**From:** Jeff Watson  
**Sent:** Tuesday, March 26, 2013 9:04 AM  
**To:** 'Chuck Cruse (cruseandassoc@kvalley.com)'  
**Subject:** BL-13-00003 Teanaway Valley  
**Attachments:** BL-13-00003 Teanaway Valley Master File Compressed.pdf

BL-13-00003 Teanaway Valley

PROPOSED

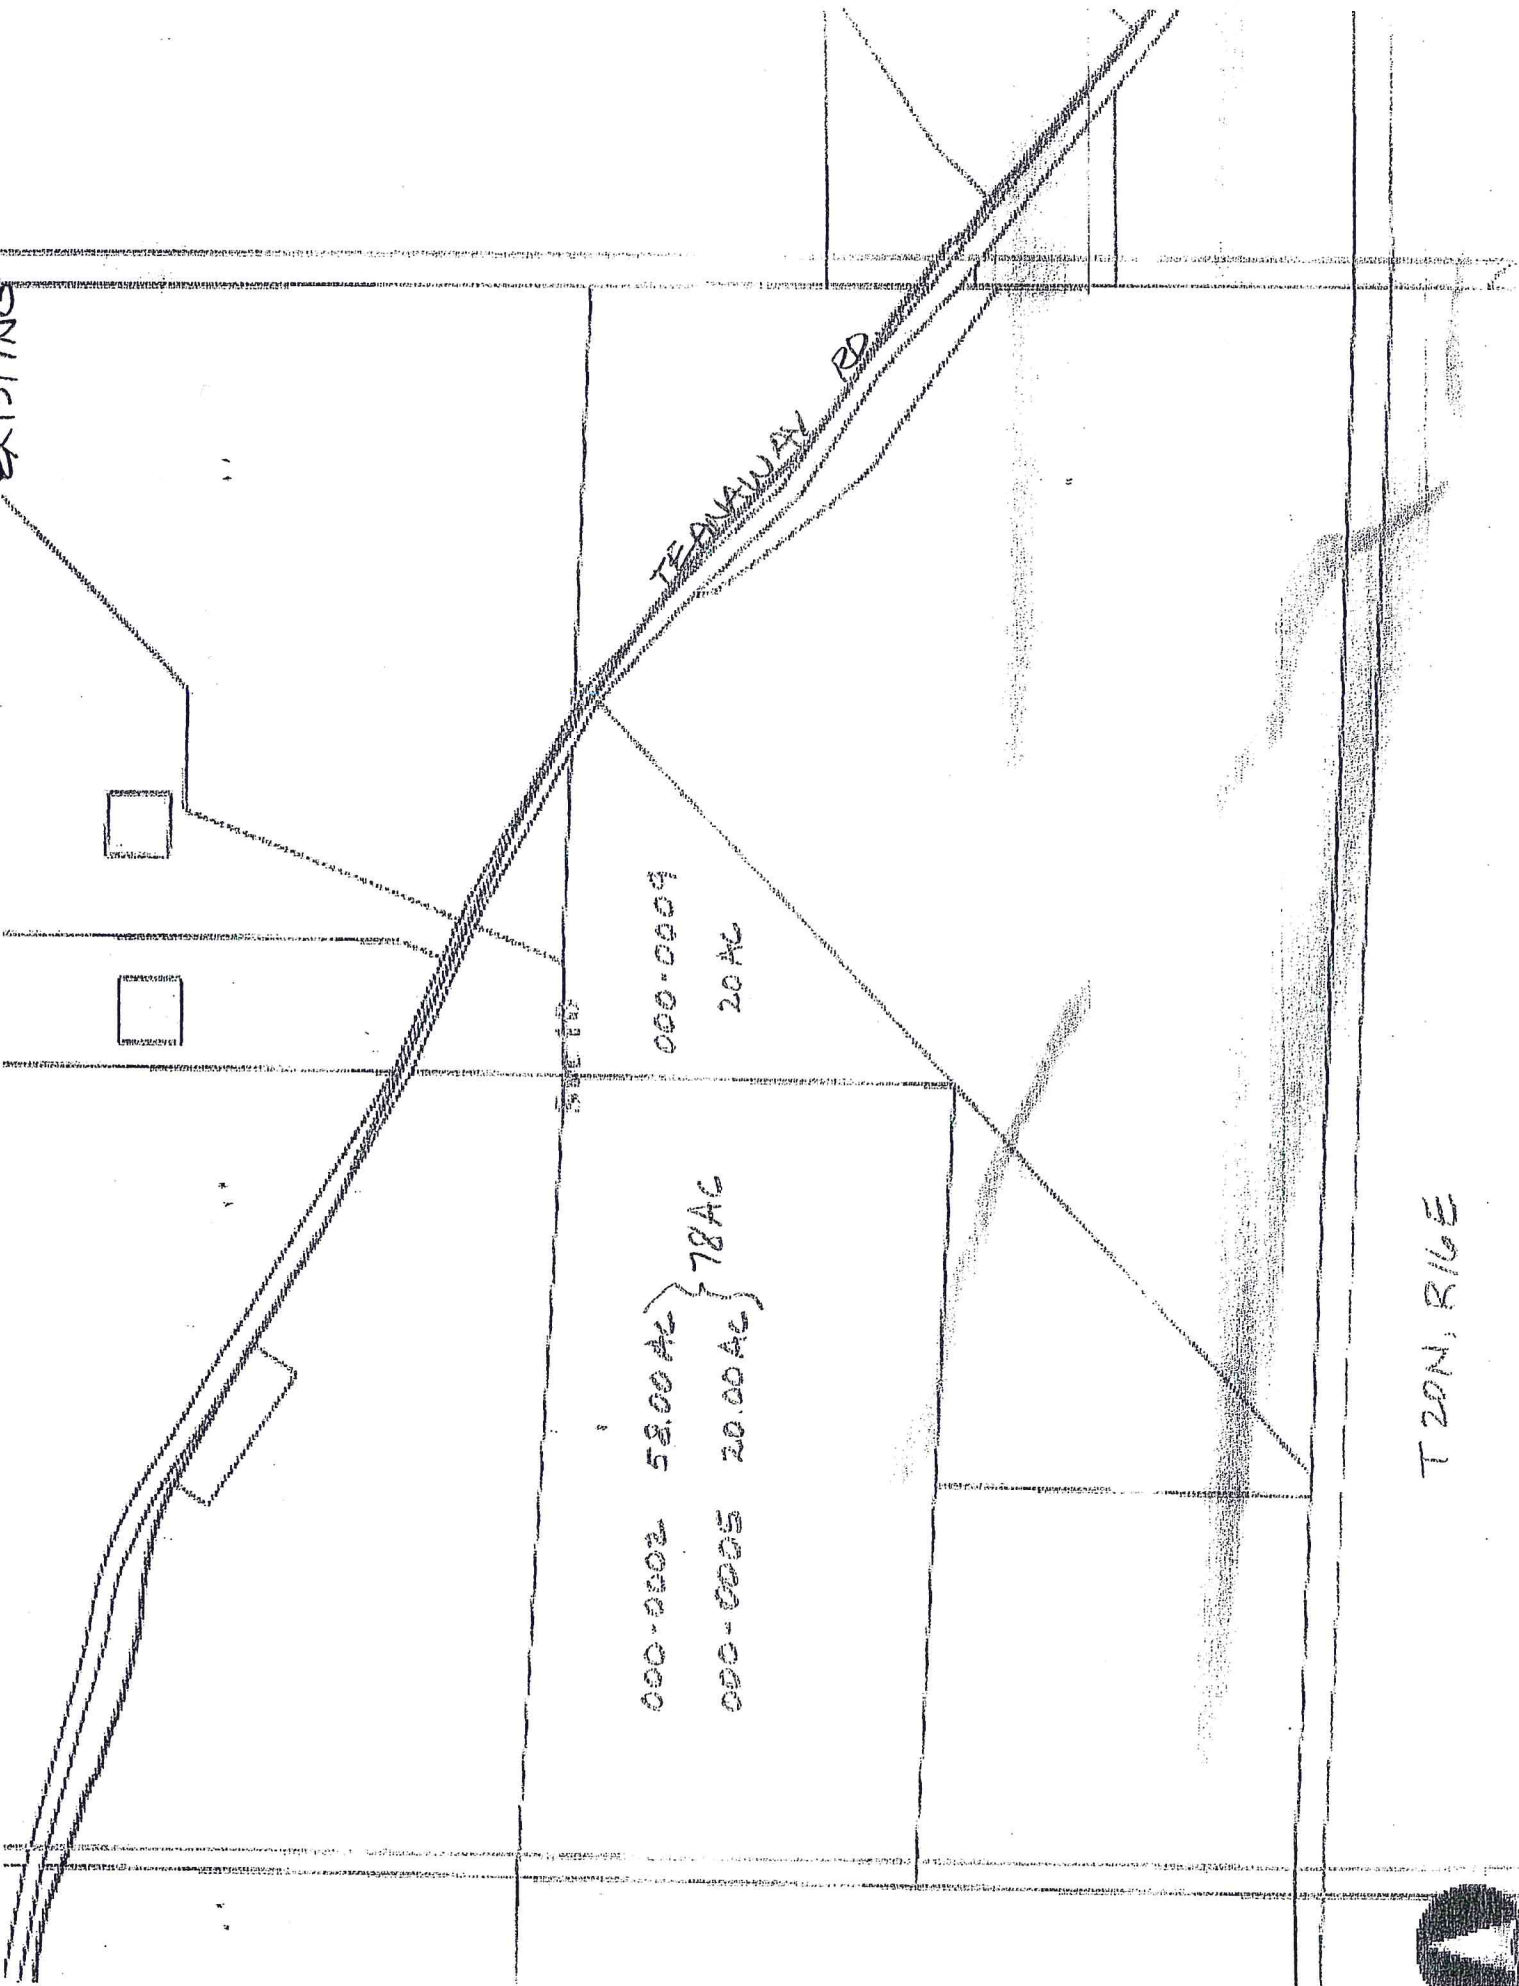
I got this file plugged in and out for comment, but I wanted to clarify one thing. It appears from the "Proposed" exhibit that the goal is to move the property to follow the meanderings of the Teanaway River... is that the case? This would be helpful because of the split zoning on the parcel which from my interpretation was constructed in the same manner.
